29 October 2017
Our Ref: 15168

34 Yarrunga Street, Prestons

I have considered the “traffic” issues raised by the Department of Planning (letter of 30.8.17), RMS (letters of 30.8.17 and 13.10.17) and Council (letter of 24.8.17 and attached memos) and respond in the following:

PROPOSED LINEMARKING AND SIGNAGE

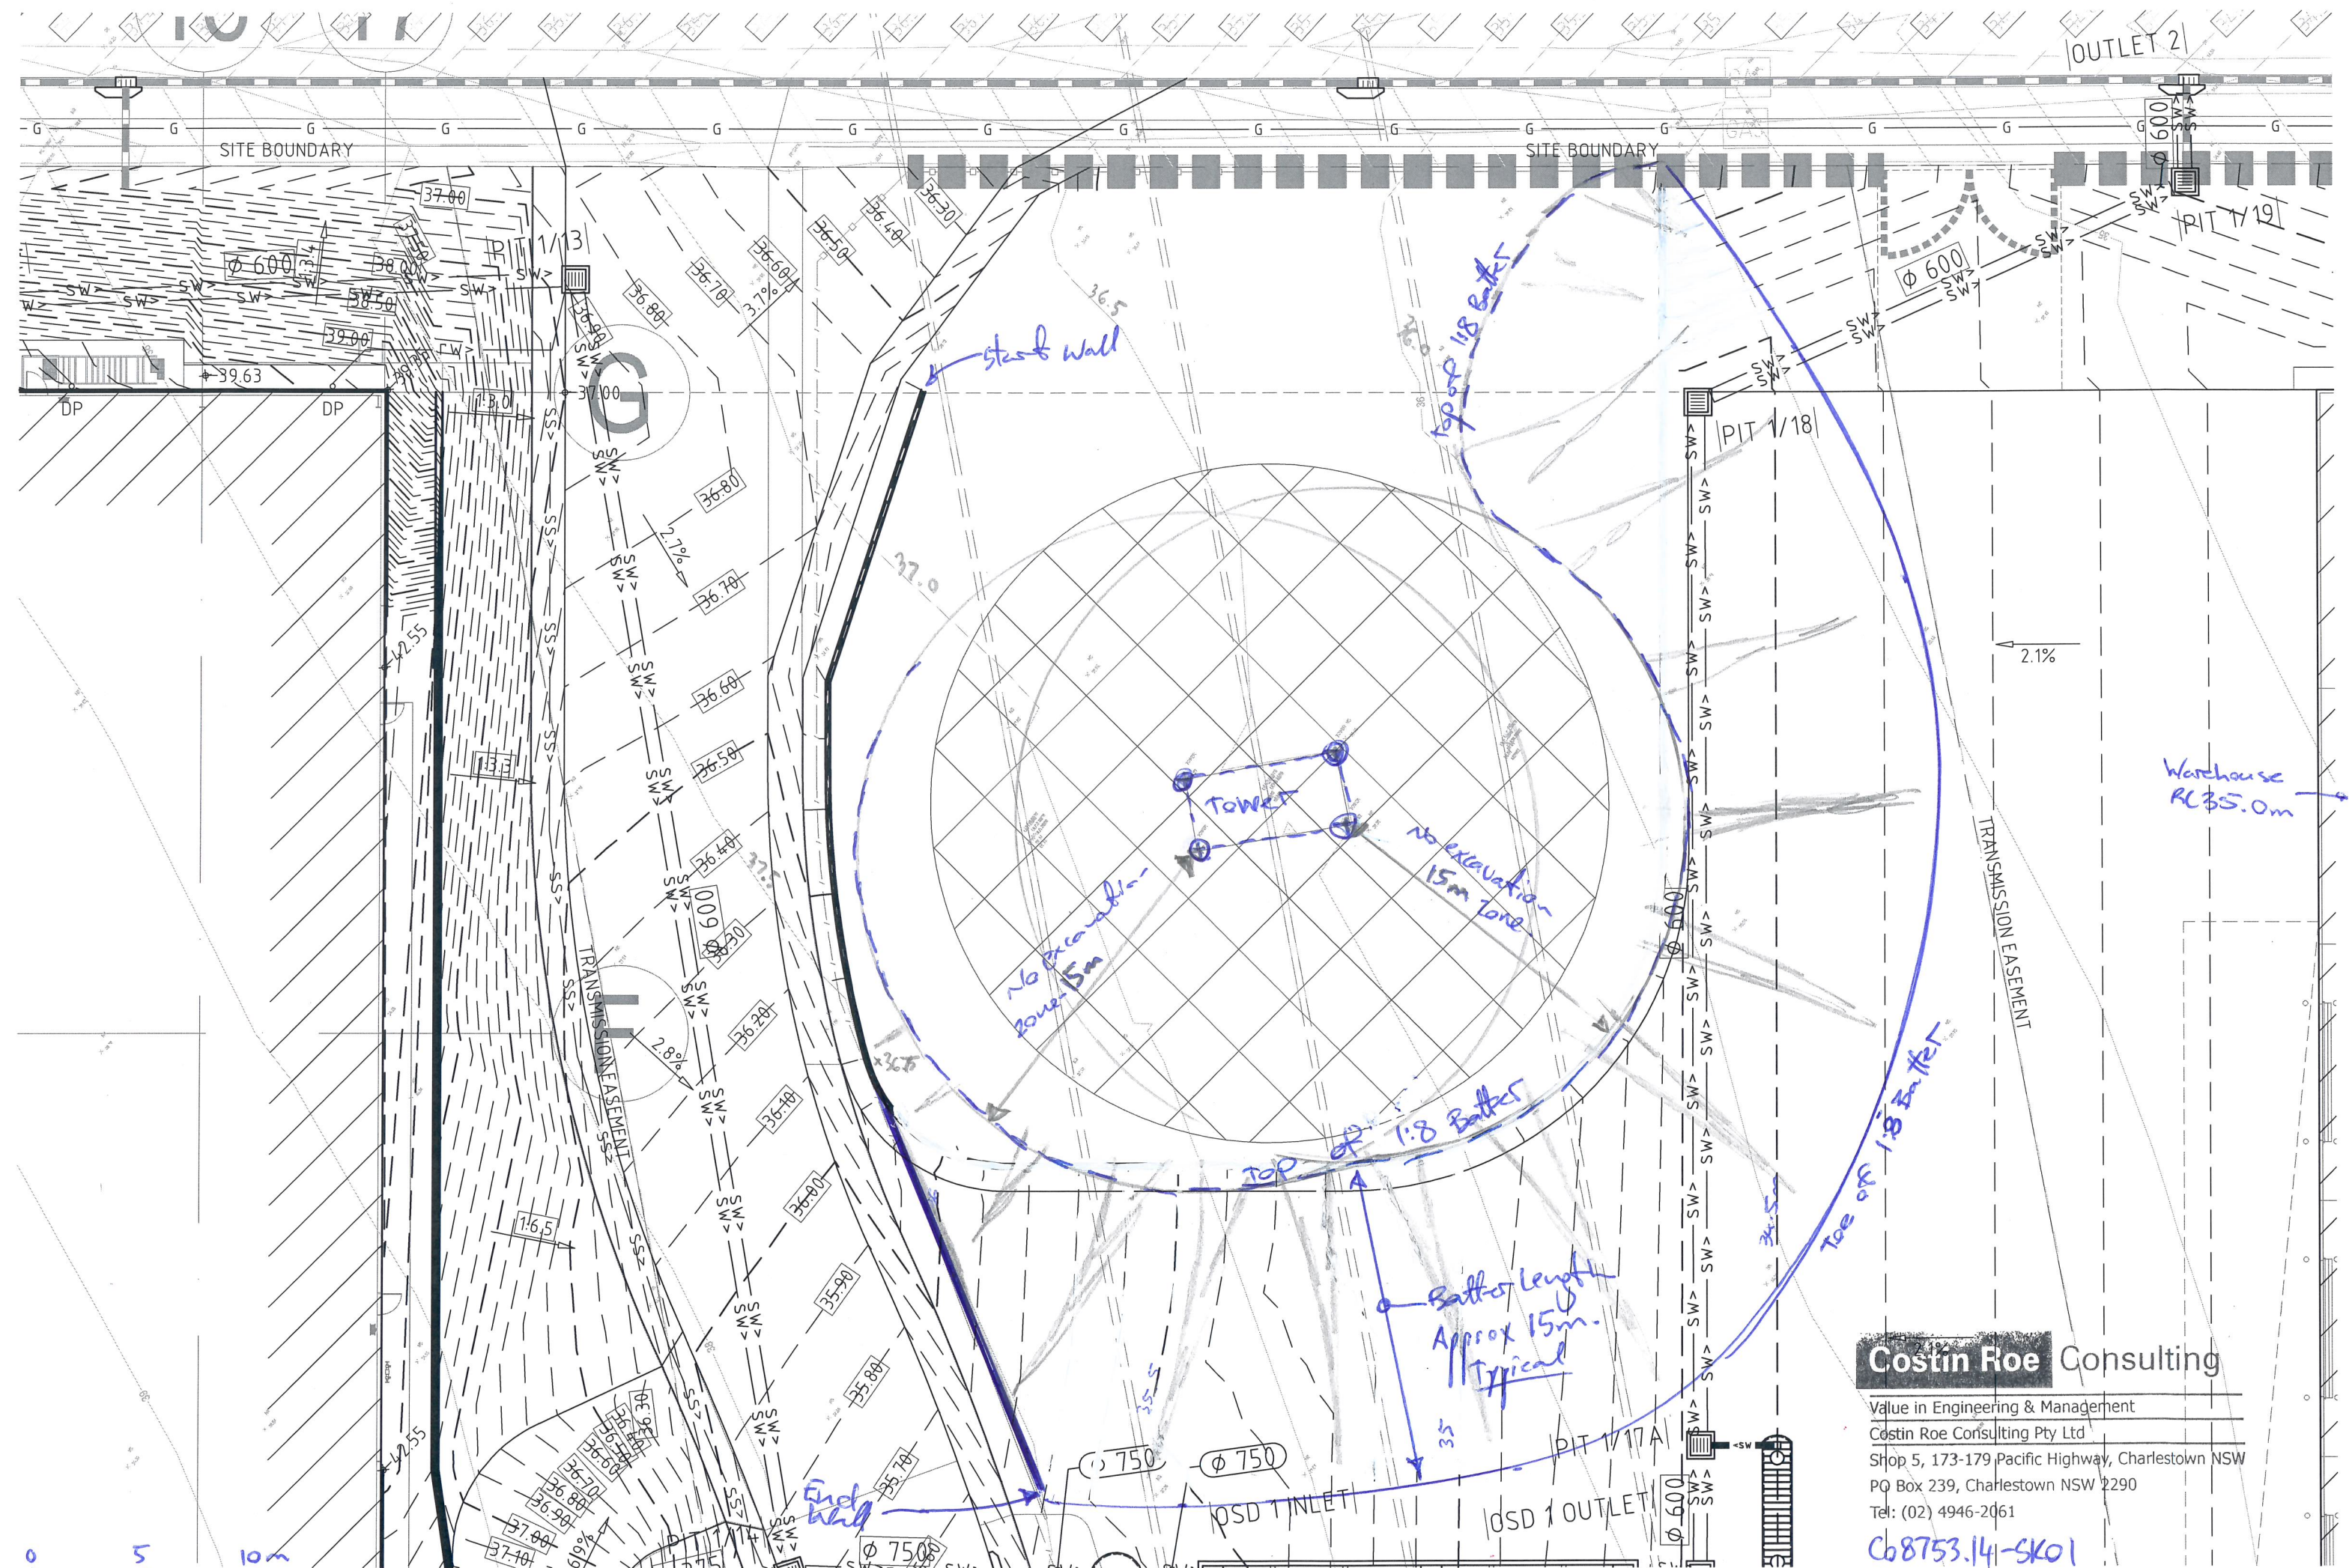
- the very predominant turning movements at this intersection are and will continue to be the movements to and from the M7 (the north)
- there is a very large H.V. transmission pole on the SW corner (right on the kerb return) and no apparent opportunity at present to acquire the land to improve the geometry of that corner
- reducing the footway widths to 2 metres on each corner would enable B Double passing however this would position signal posts in the middle of the footways (obstructing pedestrians and cyclists) and would not permit the appropriate provision for kerb ramps.

It is suggested that the way forward to achieve a satisfactory interim arrangement of this intersection is to:

- modify the proposed NW and SE corners to accommodate a semi-trailer turning left with a right turn B Double and install signage prohibiting B Doubles turning on green arrow. It is assessed that the percentage of B Double vehicles making the left turn movements will only be some 5% of the total movements and that this will not impact on the operational performance of the intersection particularly as the green arrow provision is only supplementary to the respective main signal phase movements.
- designate the centre approach lanes on Yarrunga Street and Yato Road as right turn only and provide road marking to guide the movement of turning trucks (see attached plan).
